16th January 2012

The Town and Country Planning Act 1990 (as amended)

Change of use from residential dwelling (C3) to ground floor chiropractors (D1) with 1st floor residential accommodation to include demolition of existing garage/store & erection of single storey extension
206 London Road Bognor Regis

location plan

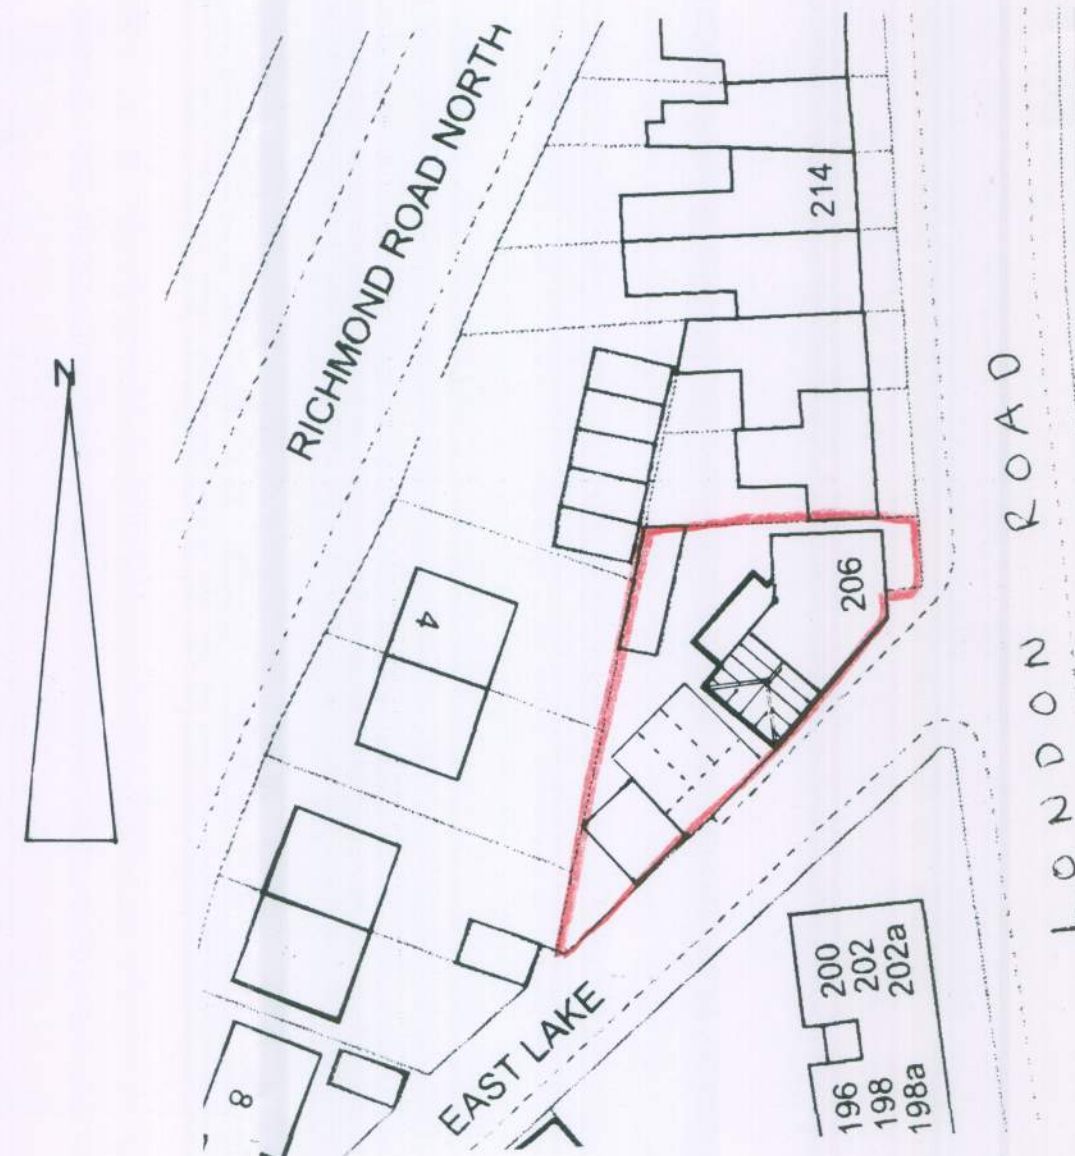
I require 1 electronic or 3 paper copies of a revised location plan showing a red edge around the application site, in accordance with the guidance notes available on our website detailed below (click on National List).

site plan

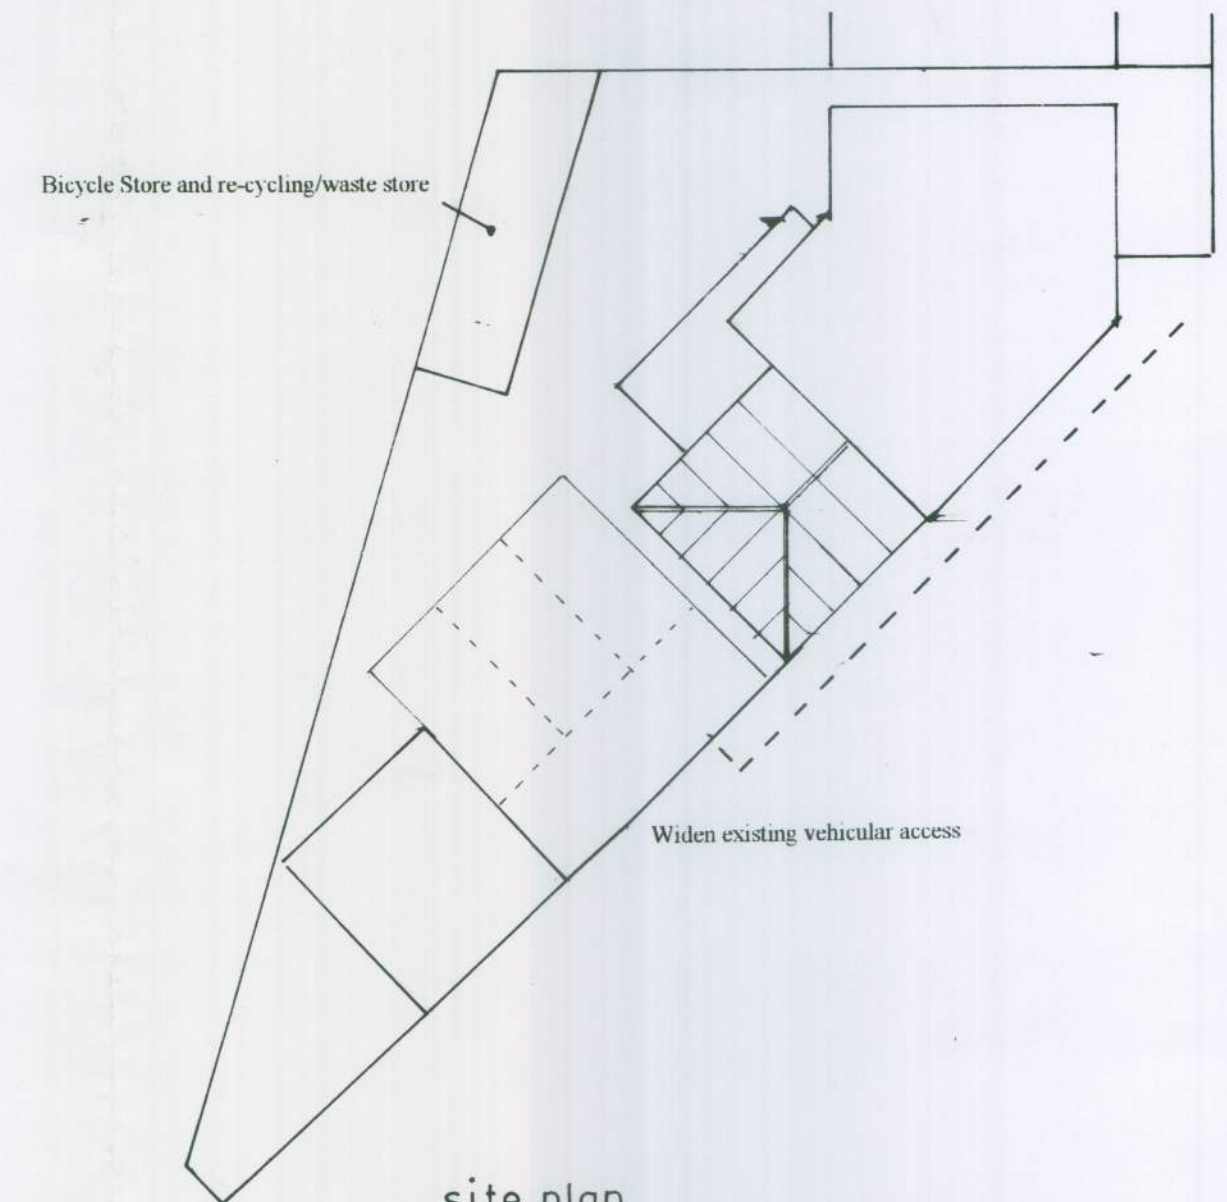
I require 1 electronic or 3 paper copies of a revised block/site plan. The plan provided only shows 3 of the 4 parking spaces indicated on the application form, in accordance with the guidance notes available on our website detailed below (click on National List).
